**United Utilities Water Limited
Developer Services & Planning**
Warrington North WWTW
Barnard Street off Old Liverpool Road
Gatewarth Industrial Estate
Sankey Bridges
Warrington
WA5 1DS

Your ref: 3/2017/0653
Our ref: DC/17/3010
Date: 14-AUG-17

Location: Land at Chatburn Road Clitheroe BB7 2EQ

Proposal: Erection of 28 dwellings with associated access, landscaping and open space.

DRAINAGE LAYOUT
SCALE: 1:500 @A2
REV -
C116-500 REV A

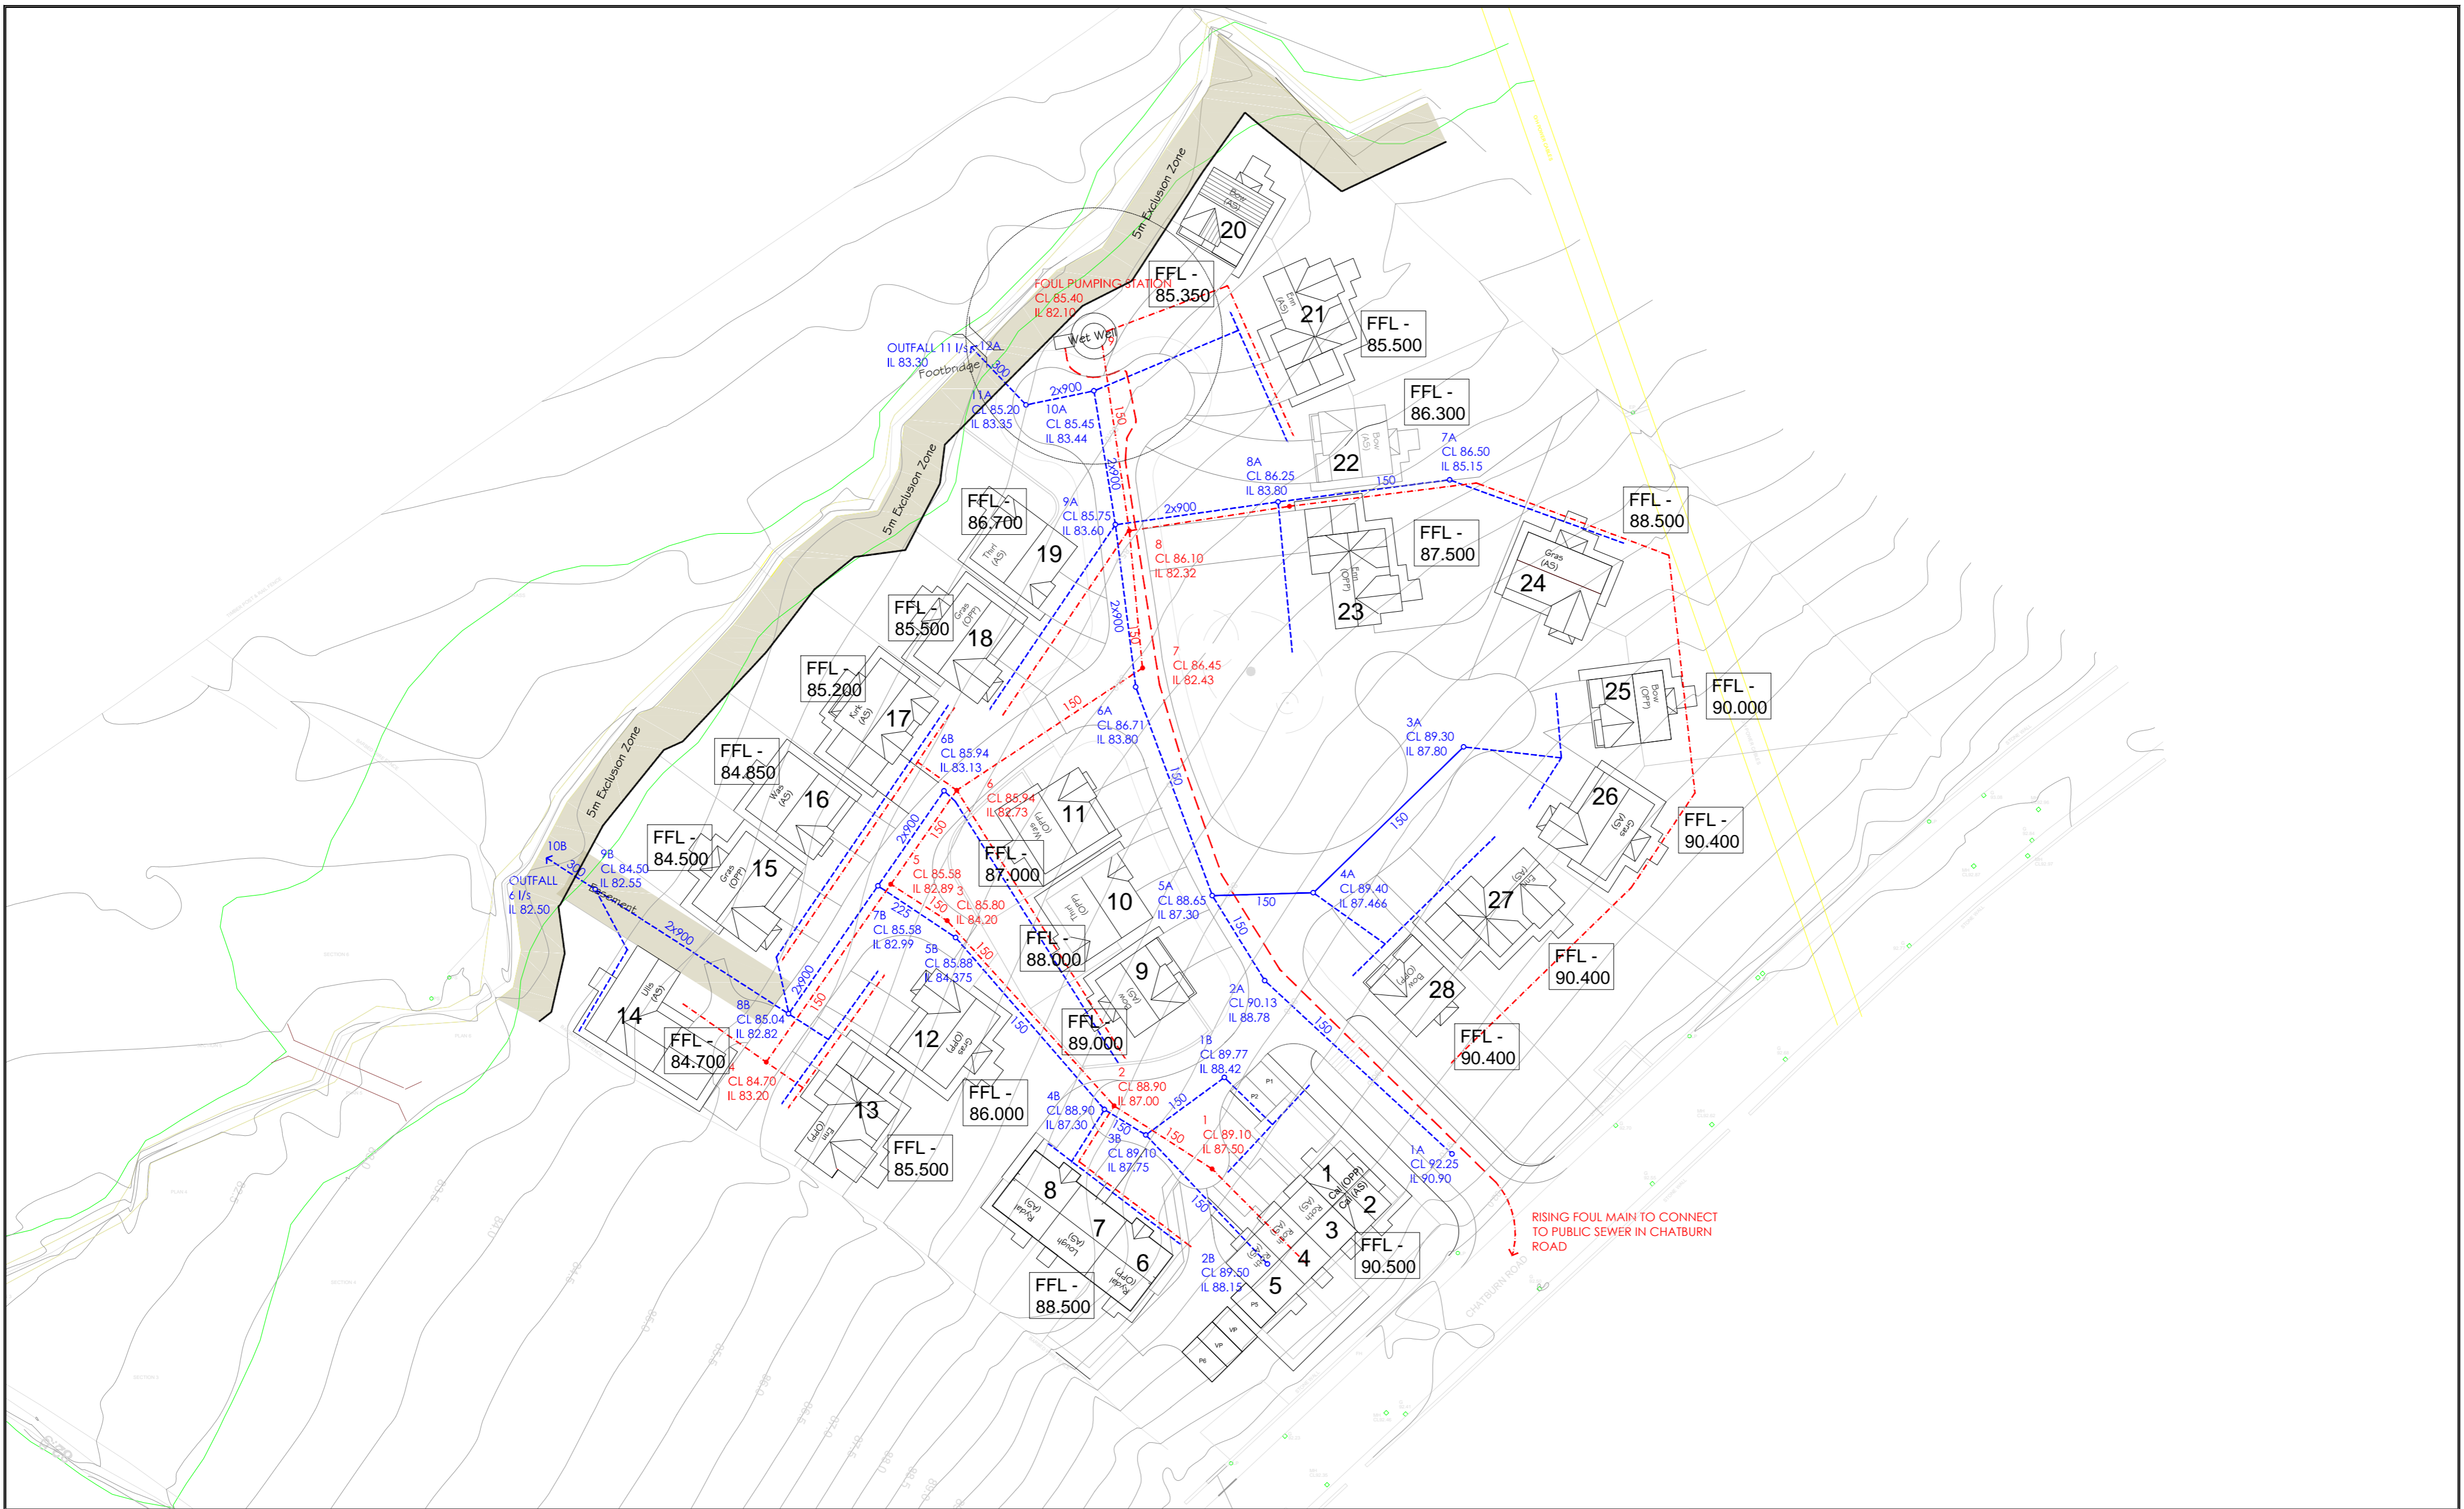
Although United Utilities would agree with the principle drainage strategy set out in the FRA and drainage design, we are concerned that the proposed foul pumping station has been sited in an area that is vulnerable to flood risk that could lead to significant pollution issues.
